PLAN SNAPSHOT REPORT PA-2025-00105 FOR CITY OF ALBUQUERQUE

Plan Type: Pre-Application Review **Project:** **App Date:** 04/18/2025
Work Class: Sketch Plat **District:** City of Albuquerque **Exp Date:** 10/15/2025
Status: In Review **Square Feet:** 0.00 **Completed:** NOT COMPLETED
Valuation: \$0.00 **Assigned To:** **Approval**
Expire Date:
Description: PR-2025-020052 Application for platting action to dedicate right-of-way and easements on Lot 25, Block 16, Tract 1, Unit 3, North Albuquerque Acres

B-20-Z

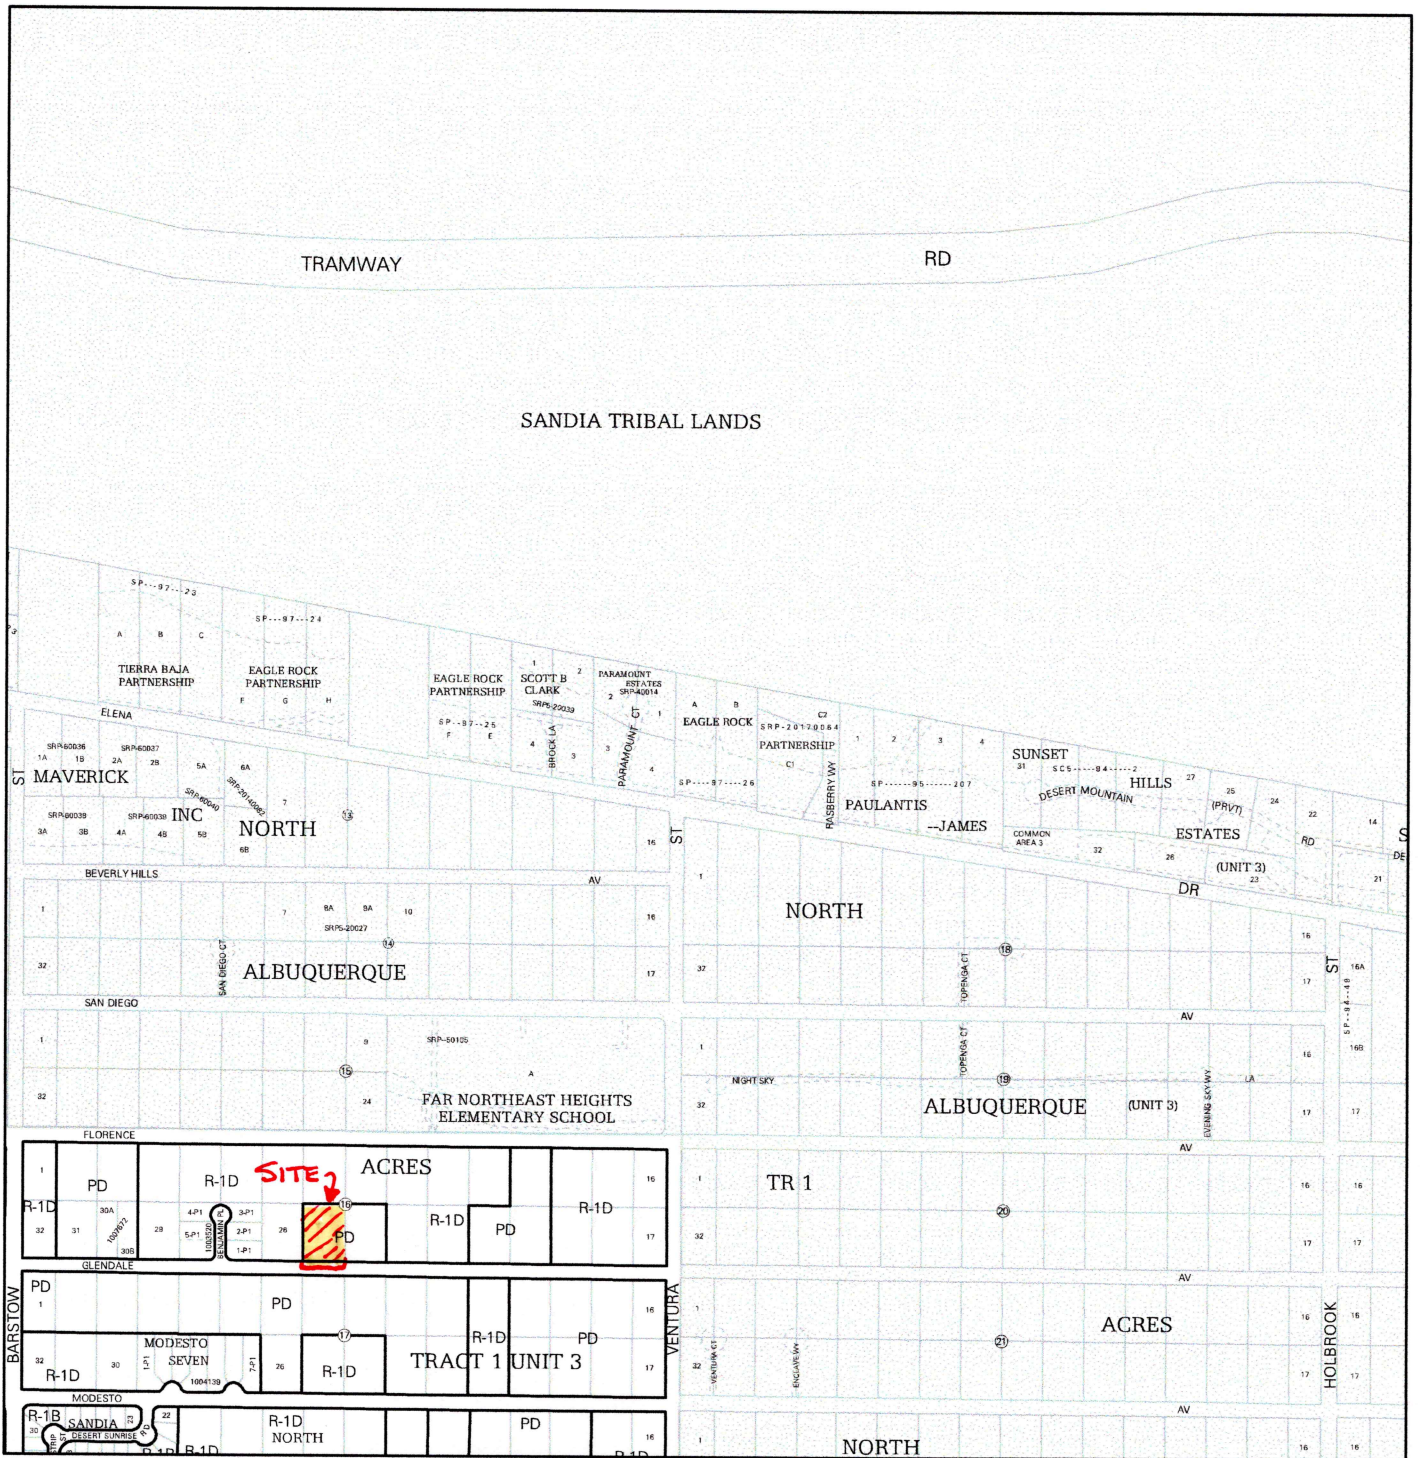
Note	Created By	Date and Time Created
1. Please clearly outline and label the entire site on the zone atlas map. The letter is blank, please provide a justification letter	Renee Zamora	04/18/2025 10:43
2. Submittal has been reviewed and is ready to be processed.	Renee Zamora	04/18/2025 13:34
